CITY OF ALBUQUERQUE

December 26, 2023

Re: Osbaldo Perez
8737 Central Ave. NW
Traffic Circulation Layout
Architect's Stamp 06-22-23 (K09-D053)

Based upon the information provided in your submittal received 12-22-23, the above referenced plan cannot be approved for Building Permit until the following comments are addressed:

**Site Development Plan**  
 (8739) 8th Street at West Central Avenue

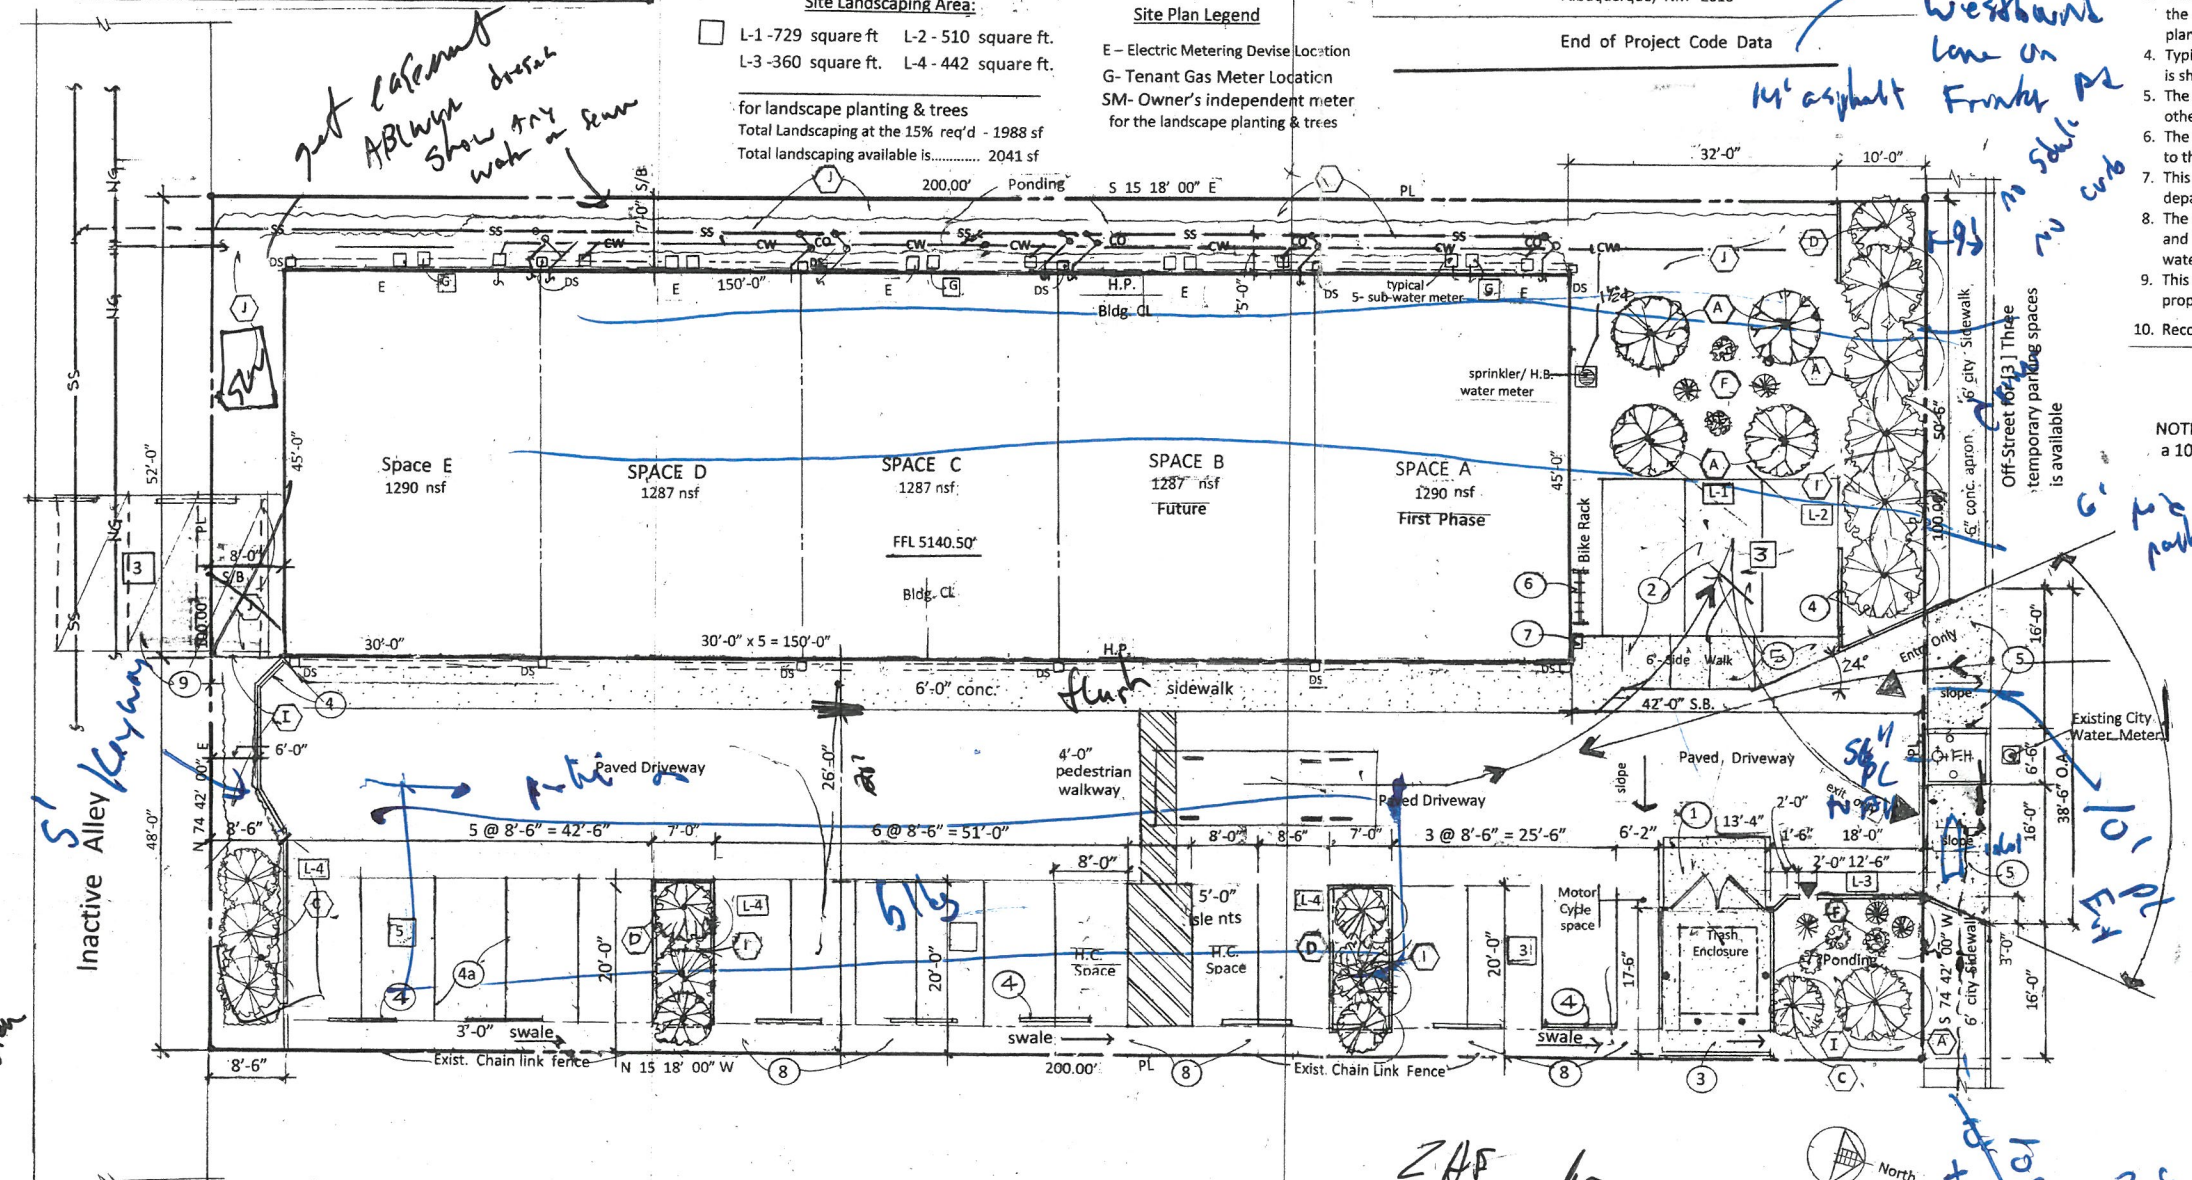
1. Please show a vicinity map showing the location of the development in relation to streets and well known landmarks.
2. List the number of parking spaces required by the IDO as well as the proposed number of parking spaces including bicycle and motorcycle parking.
3. Identify all existing access easements and rights of way width dimensions.
4. Sidewalk per City std 2430 must be developed from property line to property line off Frontage Rd. for sidewalk waiver, please contact Ernest Armijo at (505)924-3991 or earmijo@cabq.gov.
5. Please provide site access design details.
6. If the site access is one-way only please provide the following: All one-way drives shall have "One Way" and "Do Not Enter" signage and pavement markings. Please show detail and location of posted signs and striping.
7. Please clarify, what is this?

8. The minimum parking stall dimensions are:

Type of parking	Min. Width	Min. Length	Min. Overhang
Standard	8.5'	18'	2'
Compact	7.5'	15'	1.5'
Motorcycle	4'	8'	N/A
ADA	8.5'	18'	2'

9. The ADA accessible spaces must include an access aisle. Van accessible aisles should be 8ft wide.
10. The ADA accessible parking sign must have the required language per 66-7-352.4C NMSA 1978 **"Violators Are Subject to a Fine and/or Towing."** Please call out detail and location of signs.

11. The ADA access aisles shall have the words **"NO PARKING"** in capital letters, each of which shall be at least one foot high and at least two inches wide, placed at the rear of the parking space so as to be close to where an adjacent vehicle's rear tire would be placed. (66-1-4.1.B NMSA 1978)

12. Motorcycle parking spaces shall be designated by its own conspicuously posted upright sign, either free-standing or wall mounted per the zoning code.

13. The pavement marking "MC" should be shown in the opposite direction for motorcycles entering the parking space.
14. All bicycle racks shall be designed according to the following guidelines:

16. A 1-foot clear zone around the bicycle parking stall shall be provided.
17. Bicycle parking spaces shall be at least 6 feet long and 2 feet wide.
18. A 5 ft. keyway is required for dead-end parking aisles.

19. Per the IDO, a 6 ft. wide ADA accessible pedestrian pathway is required from the public sidewalk to the building entrances. Please clearly show this pathway and provide details.

20. Per DPM, a 6 ft. wide ADA accessible pedestrian pathway is required from the ADA parking stall access aisles to the building entrances. Please clearly show this pathway and provide details.
21. Please define this ADA pathway by labeling of ramps, flush and show on the site plan the main building entrance.

22. A 5 ft. keyway is required for dead-end parking aisles.
23. Please clarify, is the keynote 4 refers to curb?

24. Refuse vehicle maneuvering shall be contained on-site. The refuse vehicle shall not back into the public right of way.; provide a copy of refuse approval.
25. Please provide a copy of Fire Marshal approval.
26. Show the clear sight triangle and add the following note to the plan: "Landscaping and signage will not interfere with clear sight requirements. Therefore, signs, walls, trees, and shrubbery between 3 and 8 feet tall (as measured from the gutter pan) will not be acceptable in the clear sight triangle.
27. Please specify the City Standard Drawing Number when applicable.
